Sheringham Shoal Extension and Dudgeon Extension Offshore Wind Farms

Appendix L1 to the Natural England Deadline 2 Submission

**Natural England's Further Response and Comments on Responses by the Applicant
[REP1-036] to the Examining Authority's First Written Questions**

Planning Inspectorate Reference: EN010109

Figure 14. MNCR benthic sediment habitats within the SEP-DEP export cable corridor with Cromer Shoal Chalk Beds MCZ feature map

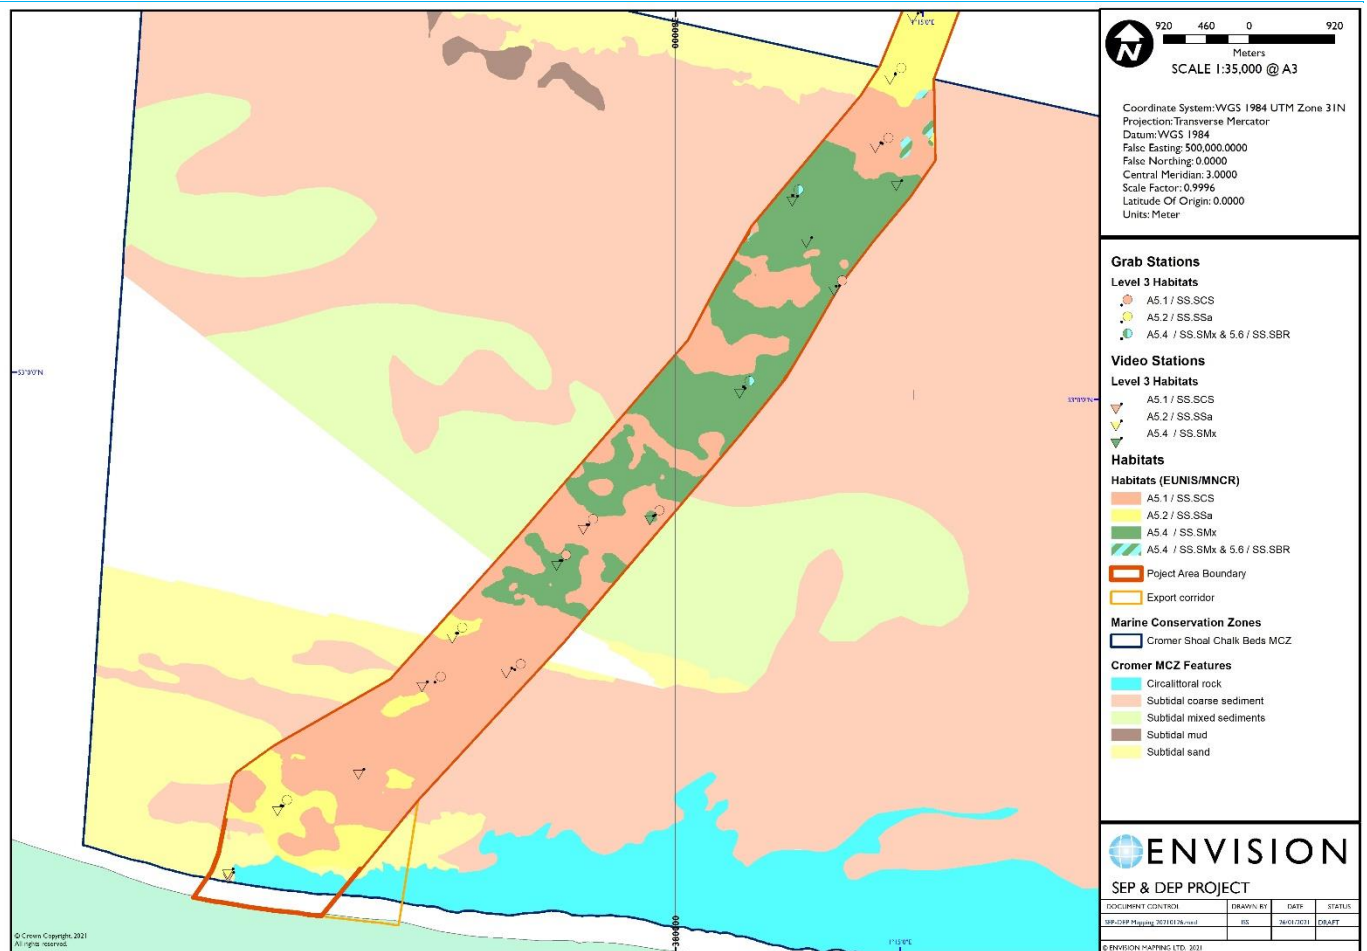
<p>this broadscale habitat feature within the cable corridor. As would be expected, there are differences in the distribution of habitats between the MCZ feature map (Natural England, 2020; Green and Dove, 2015) and the Applicant's own mapping, which is both more detailed and more recent. These differences are evident between Figures 7.1 and 7.2 of the Stage 1 MCZA [APP-077]. Specifically, with respect to subtidal mixed sediments (MCZA para 109), the Applicant's habitat mapping confirms that mixed sediment areas form a mosaic with subtidal coarse sediment areas for much of the offshore export cable corridor within the CSCB MCZ (these are the areas shown in green and orange on Figure 7.2). It is noted that it is difficult to delineate subtidal coarse and subtidal mixed sediment habitats in the offshore export cable corridor due to their similarity, with mixed sediment areas being close to the coarse sediment areas with a relatively low percentage of fines, but sufficient</p>

1. Methodology based on function of broadscale habitat. Doesn't account for sub-features of broadscale features which do have defined function and sensitivities for which impacts should be avoided. (See NE R&I Log, point G2). Discussions ongoing

<p>fine material to influence benthic communities.</p> <p>The key implication of this is that there can be no basis for any requirement to avoid areas of broadscale subtidal mixed sediment because they exist in a mosaic with other habitat types and it is not possible or appropriate to attempt to confirm their exact distribution, which is also likely to vary over time (Natural England, 2020).</p> <p>The final point relates to the suggestion that the mixed sediment areas have a more diverse community. This may be the case although as above cannot be said with any certainty with respect to any particular location due to the mosaic pattern of habitat distribution. Furthermore, as described in Section 8.2.2.2 of the Stage 1 MCZA [APP-077] (para 200) "All sediment biotopes, including those recorded in the SEP and DEP offshore export cable corridor, and the biotopes</p>	
--	--	--	--	---	--
